**Application by Application by Equinor for an Order Granting Development Consent for the Sheringham and Dudgeon Extension Projects**

**South Norfolk Council – Response to S56 Consultation Sheringham Shoal Offshore Wind Farm Extension Project and Dudgeon Offshore Wind Farm Extension Project**

**Proposal: National Infrastructure Application for an Order Granting Development Consent to construct and operate two offshore wind farm generating stations, known as Sheringham Shoal Offshore Wind Farm Extension Project (SEP) and Dudgeon Offshore Wind Farm Extension Project (DEP), both located off the coast of Norfolk (together “the Projects”).**

Figure 36: UK Hab Proposed Results Map 36 (Pockthorpe to Ketteringham)

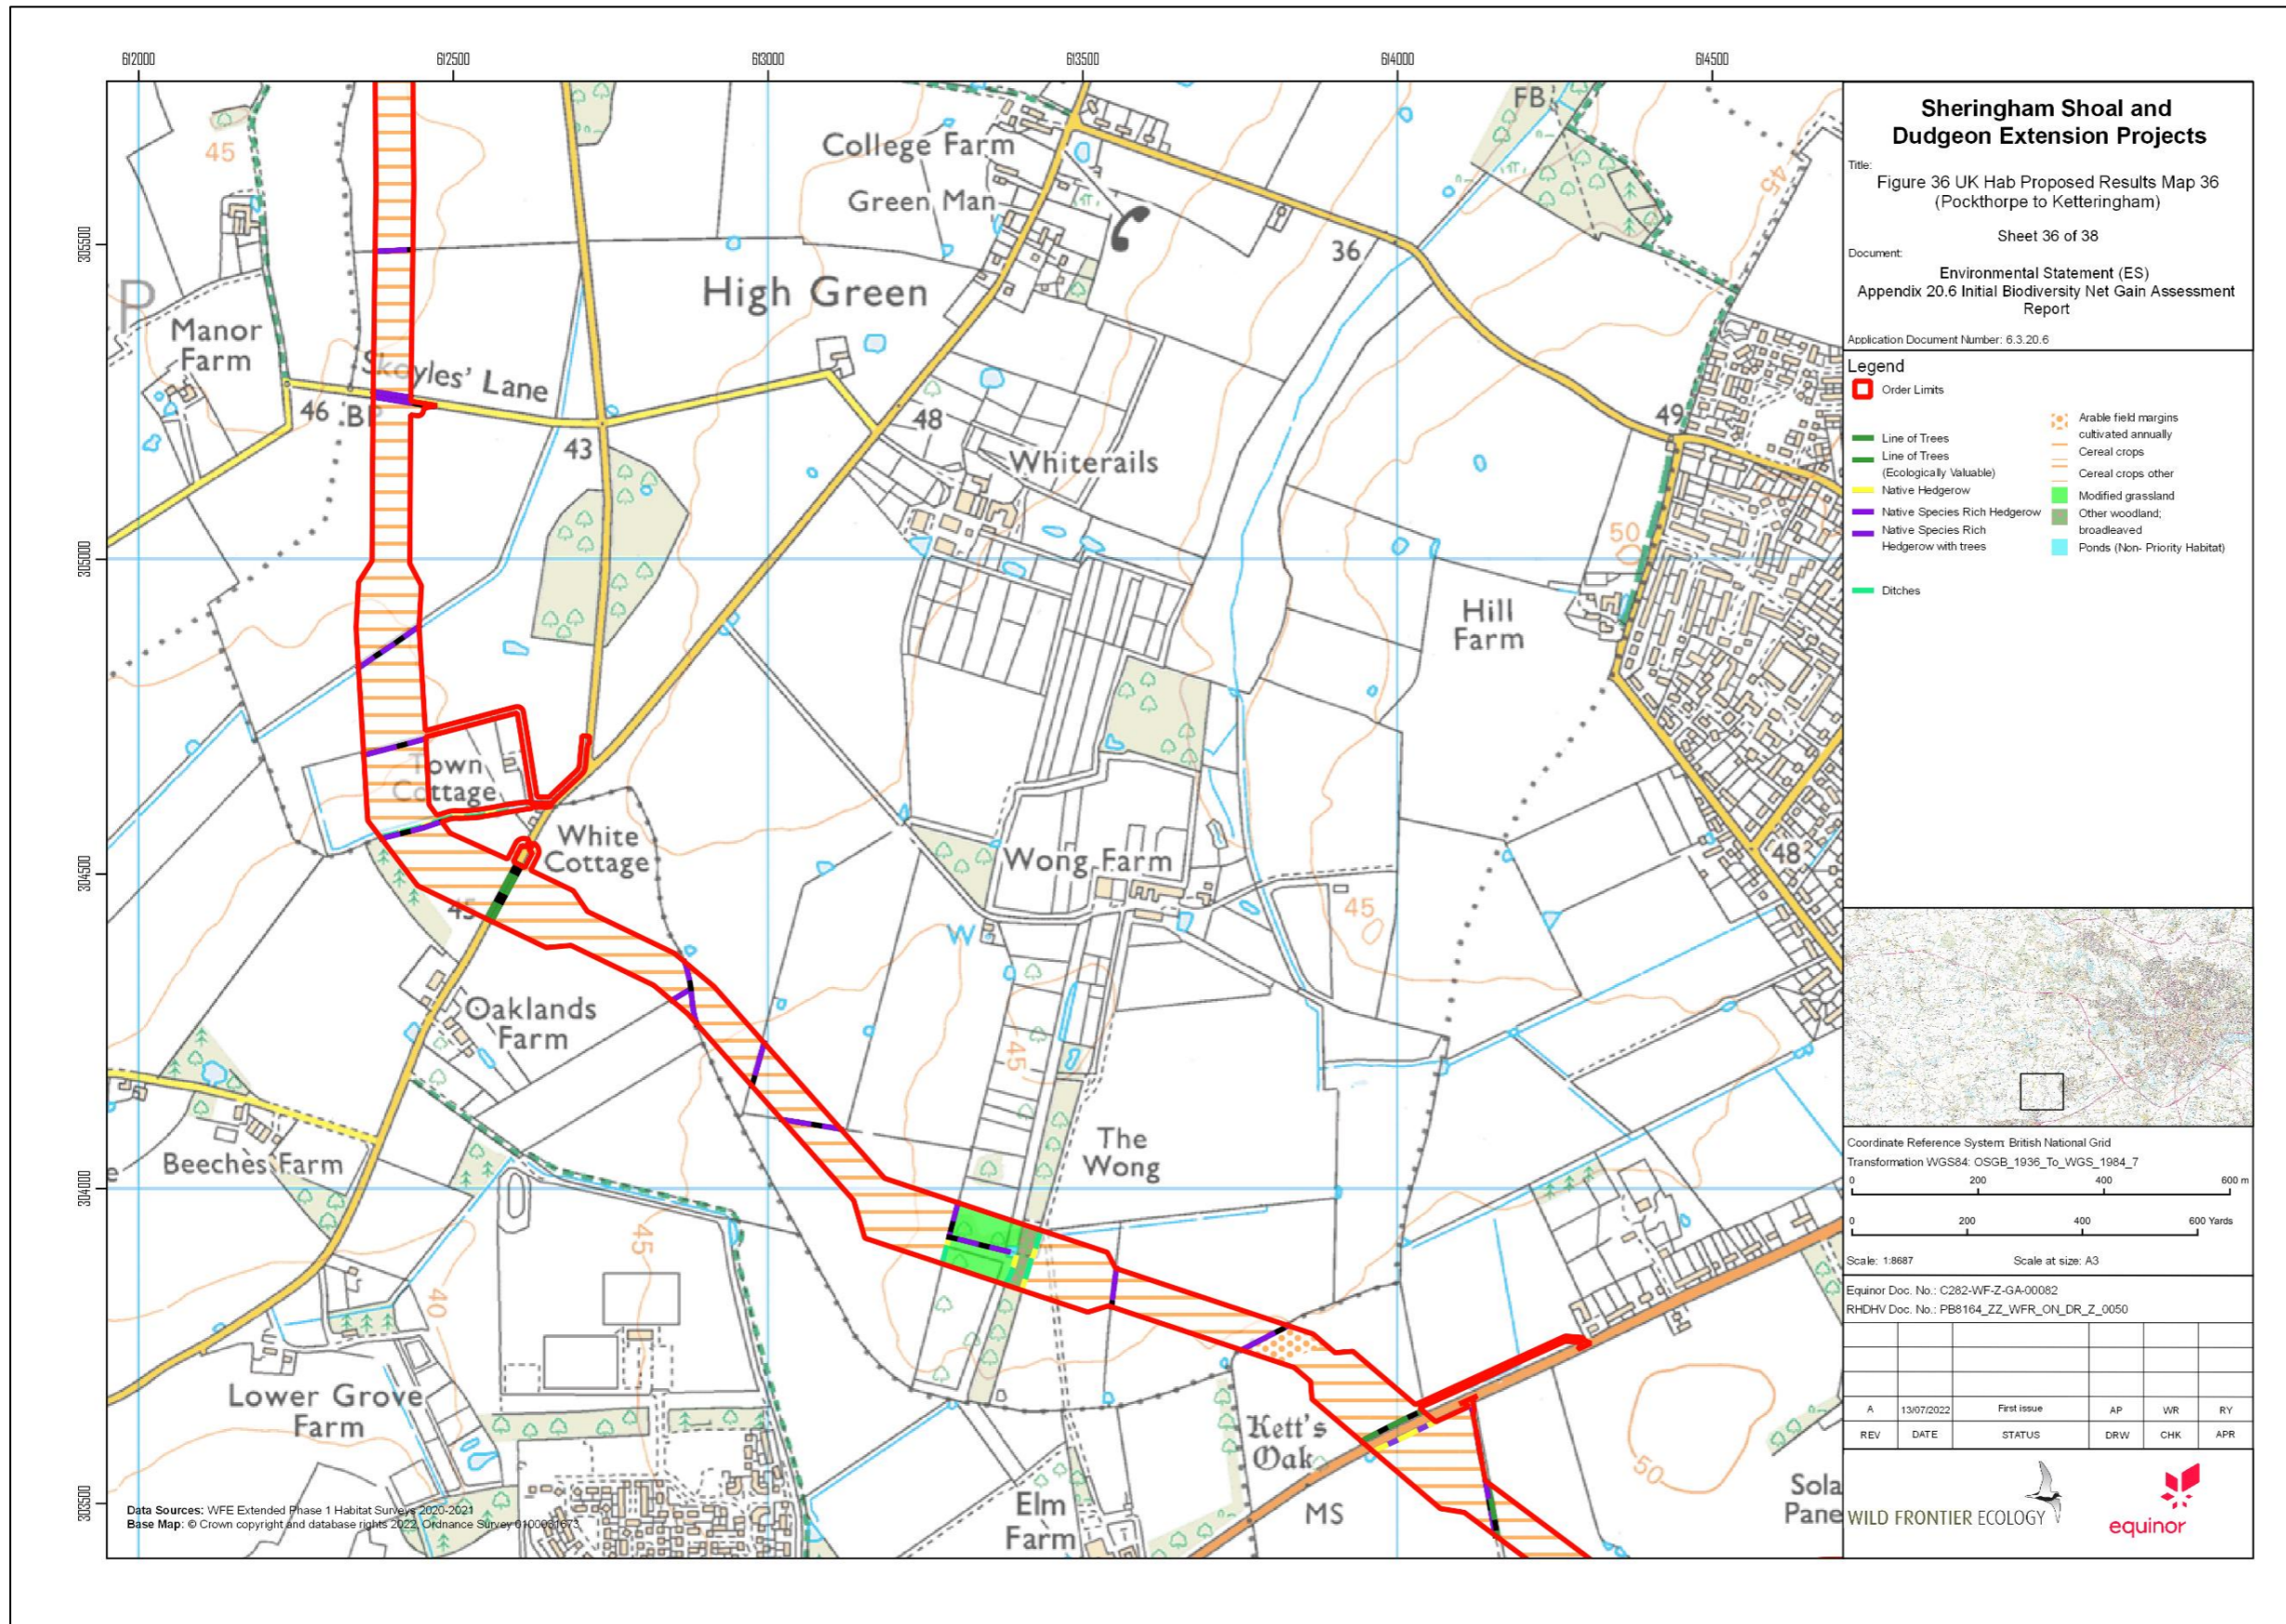
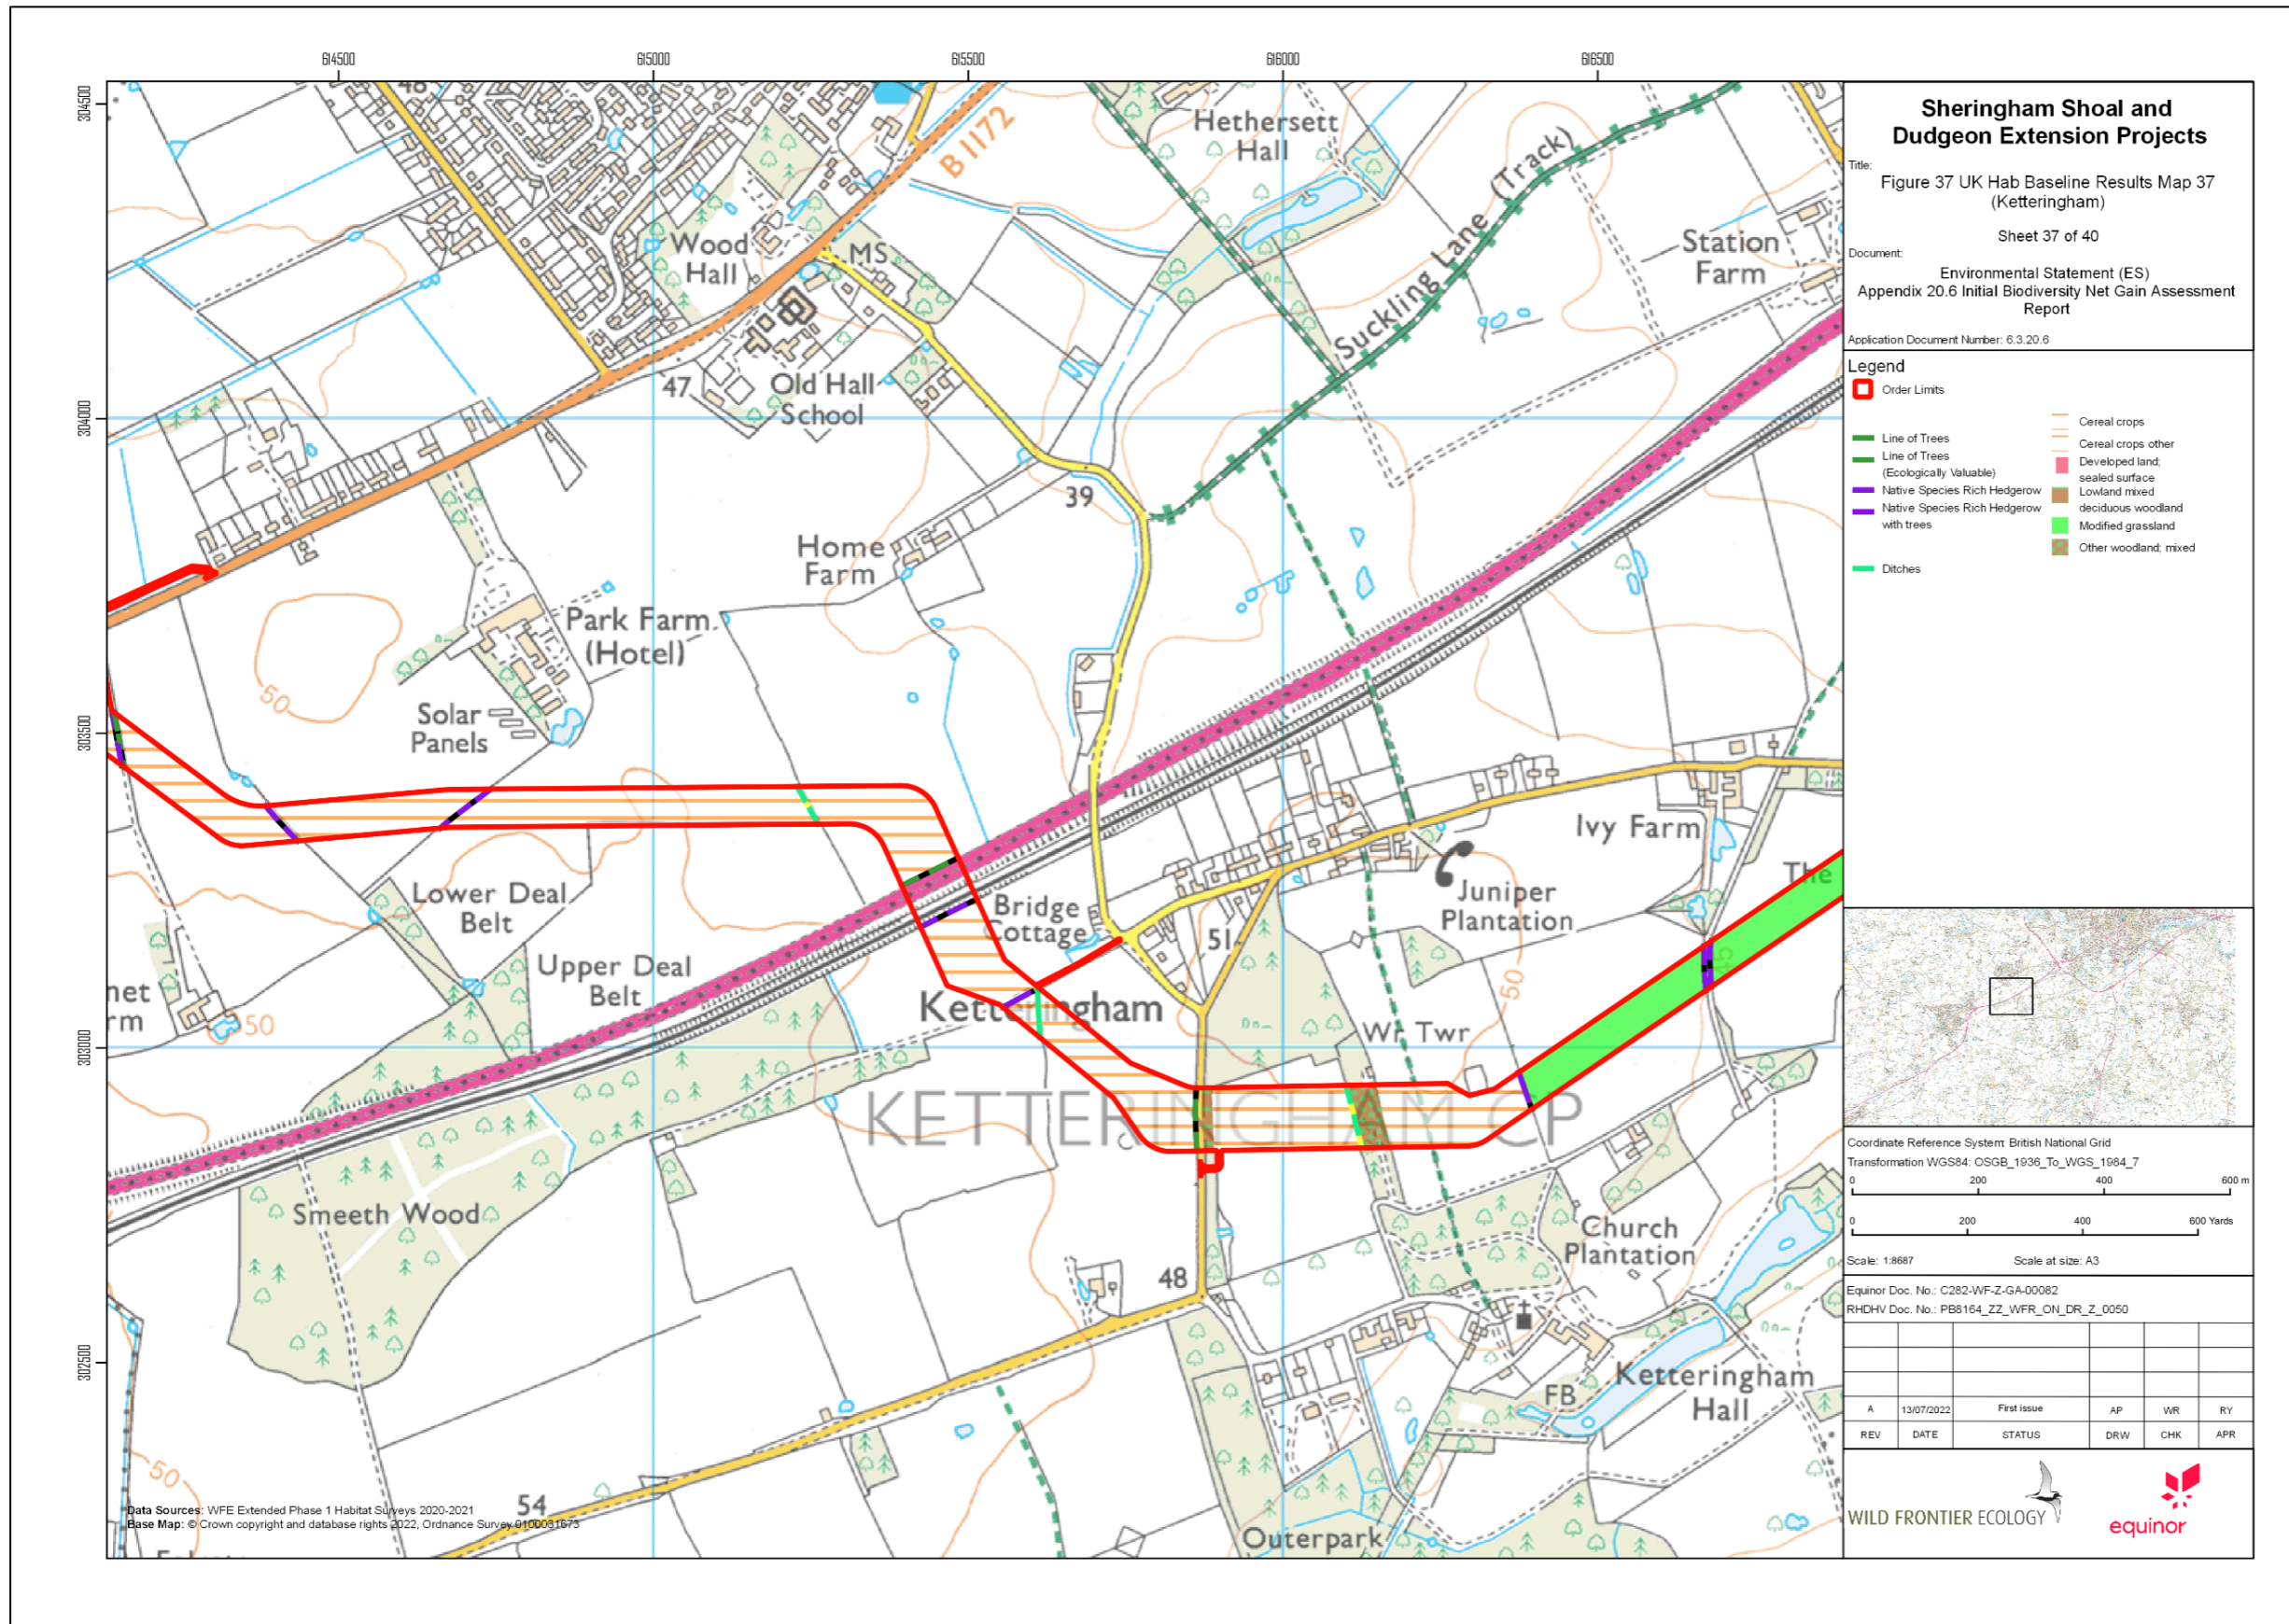
The Council consider that further clarification needs to be undertaken regarding the impact on the project on Ketteringham Hall Park which is a historic parkland and garden although not registered which is identified on Historic Environment record and can be considered a non-designated heritage asset.

It is also noted as above that the cable route is passing through Ketteringham Hall Park and through some planted plantation belt historic feature "The Oval" so could potentially involve removal of some C19th trees, which if this were the case would have a harm on the Landscape character of the designed parkland.
